May 21, 2014

Ms. Jean Fraser, Planner  
Planning and Development Department  
City of Portland  
389 Congress Street  
Portland, Maine 04101-3509

**Subject: 421 Warren Avenue  
Final Site Plan Application/Delegated Review Stormwater  
Comment Response #2**

PROJECT PH WARREN AVENUE, LLC
SHEET TITLE SITE LAYOUT AND UTILITY PLAN

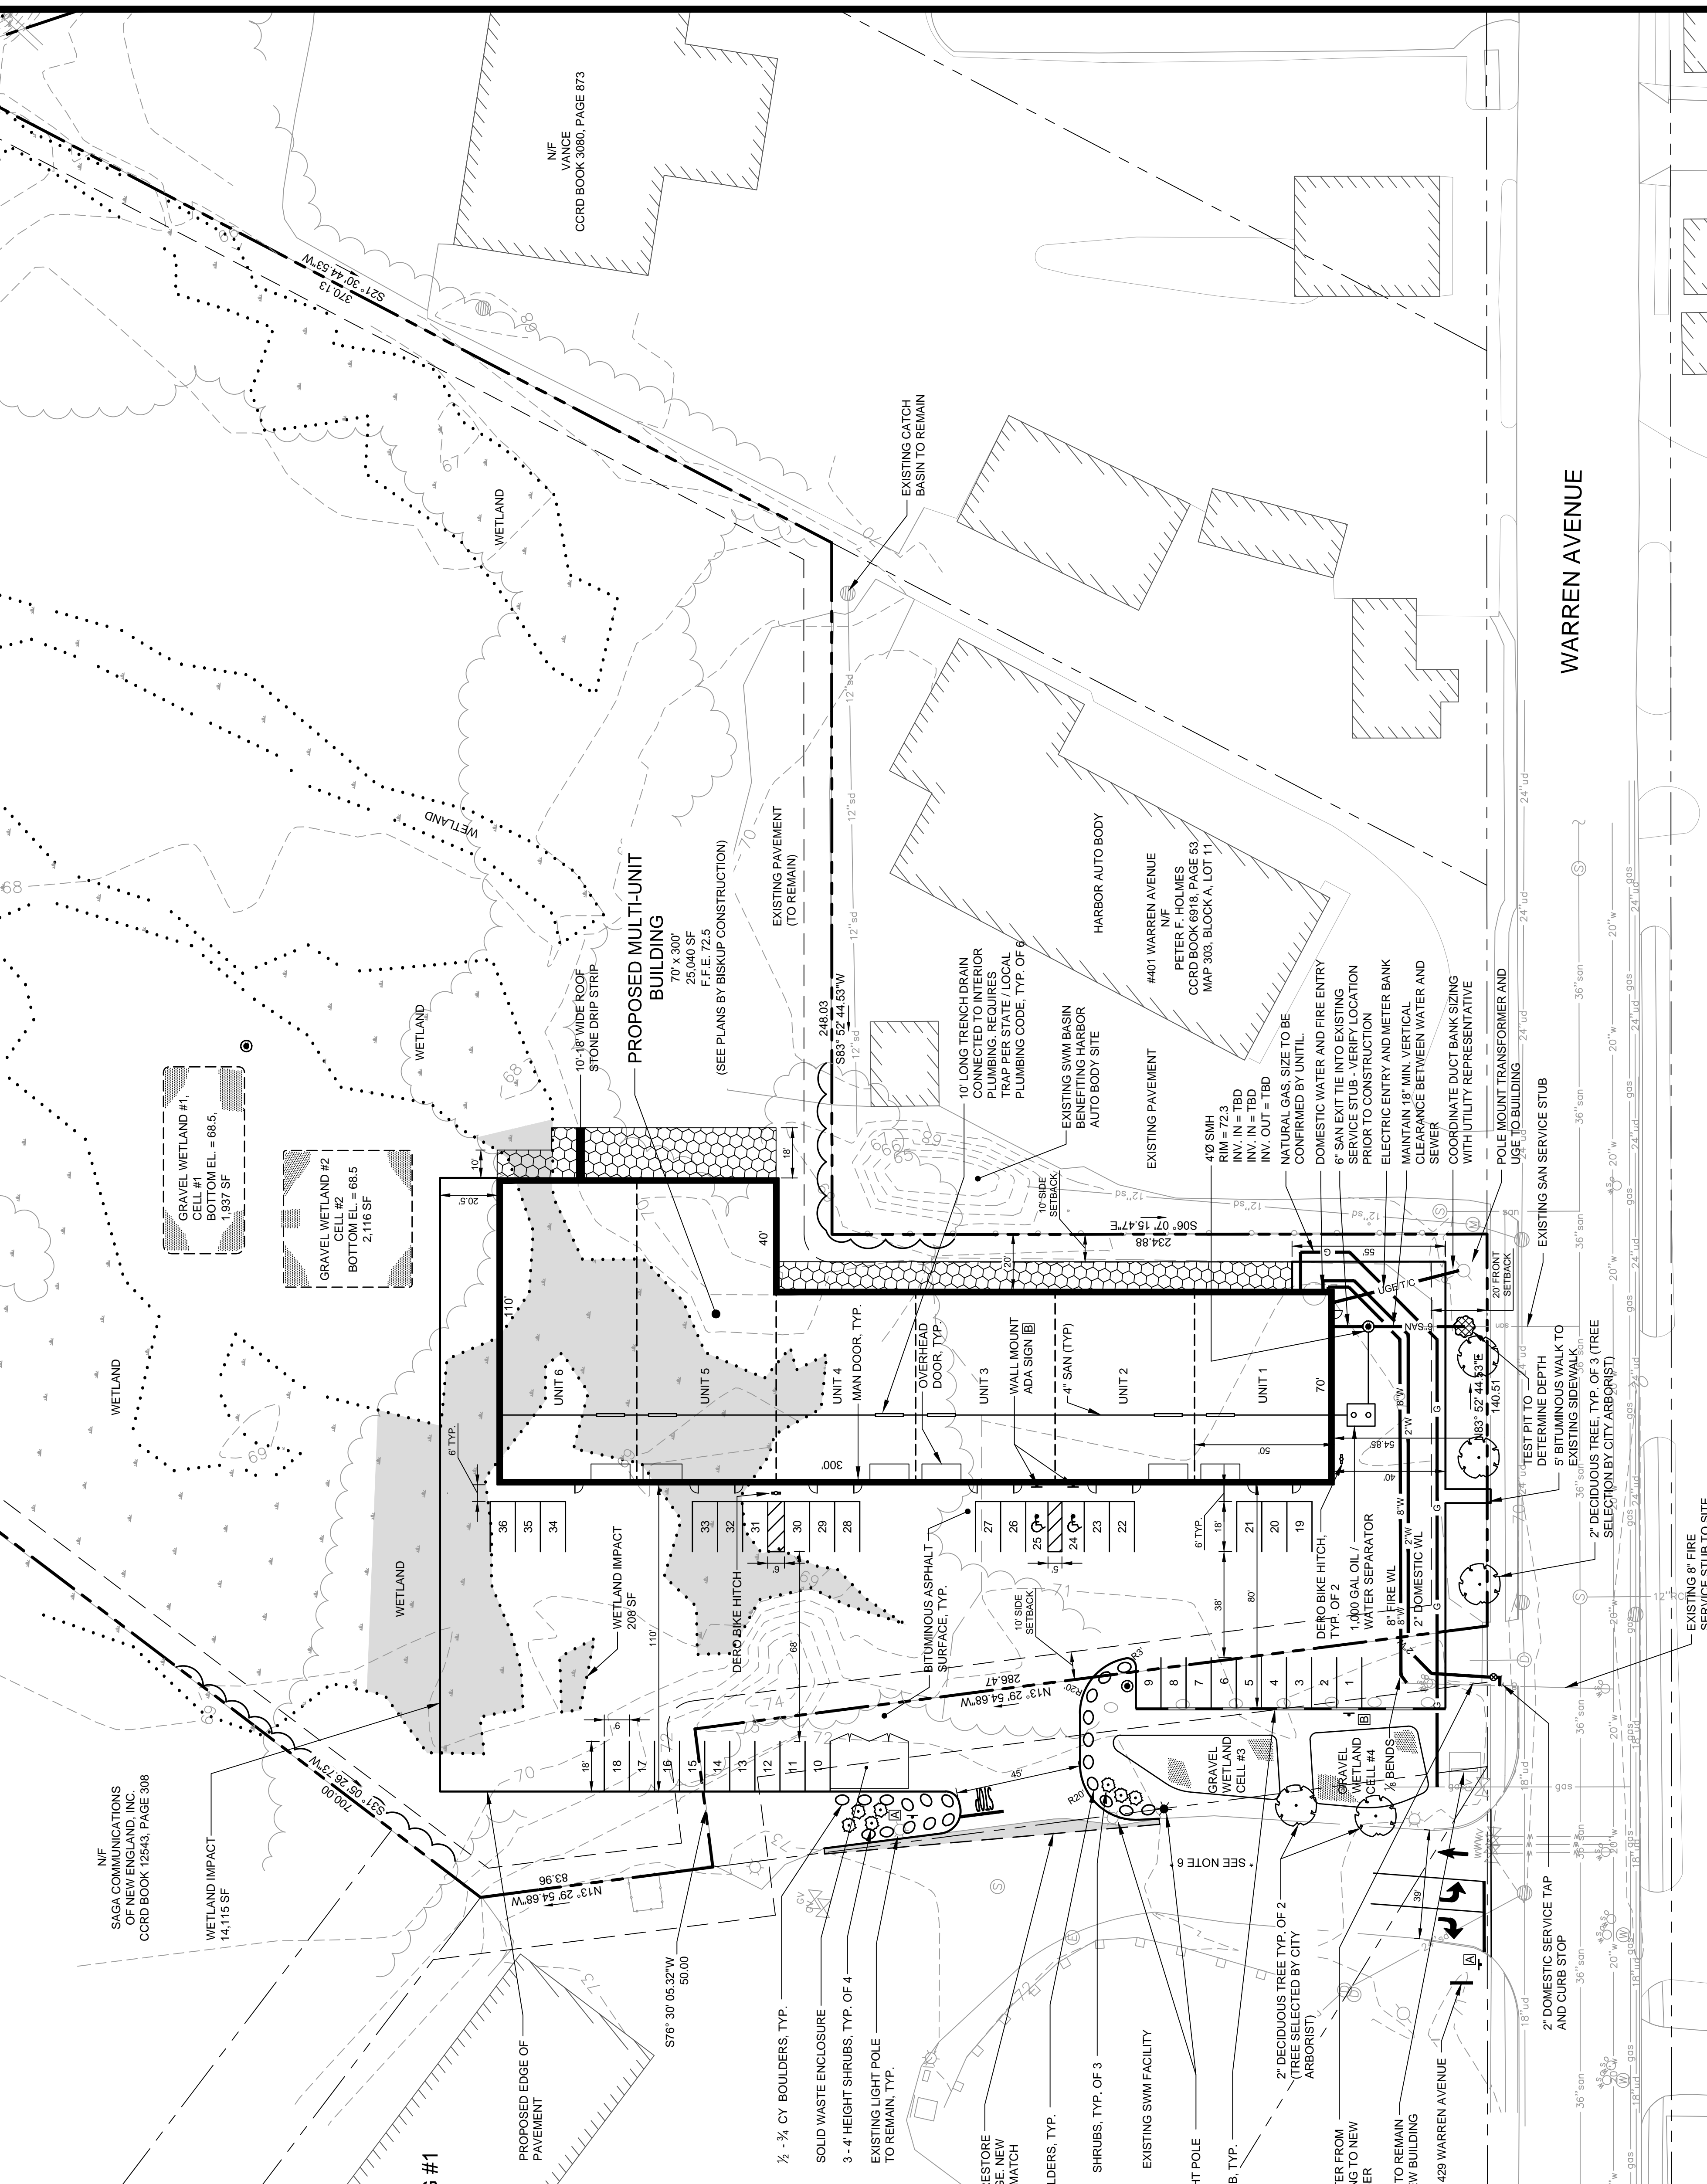
*Comment 1: Why is the 20 feet alongside the building needed? (north side)*

*Comment 2: What do trucks do if cars are parked in parking spaces?*

*Comment 4: All of these questions relate to the strong staff view that the shape and extent of the paved area is not necessarily supporting the proposed industrial/commercial function intended and that the paved area in the corner and along the north side (where it takes the trees/wetland) is un-necessary as its not used for parking nor truck maneuvering.*

Response: The applicant intends to use this area for snow plowing and parking of a snowplow during the winter. Having operated the property at 429 Warren Avenue, it is the applicant's experience that having this small paved area adjacent the building is beneficial.

Response: The applicant has experience with operations of a similar facility at 429 Warren Avenue, thus they know that the majority of larger semi-trailer truck visits are made when the parking area is empty or partially occupied. On occasion they may cone off sections for deliveries. The applicant has considered the layout closely with their experience and operational needs of similar sites he owns in Portland and previously owned in Lewiston. Based on the anticipated tenant uses for the building, the applicant is firmly of the opinion that the proposed layout is required and will be satisfactory for the intended use.

Response: The applicant's site development layout has undergone a series of revisions and cut backs to meet natural resource impact thresholds among other things. On this basis we are satisfied as to the layout and will present to the Planning Board the layout as currently submitted, despite possible continued staff reservation on size and impervious area. We note that the site still only constitutes less than a 10% development area of the 48 acres owned by the applicant. This, along with the design measures for stormwater being fully compliant with local and State regulations, seems sufficient evidence to support the applicant's goal of site plan approval on the plan as designed.
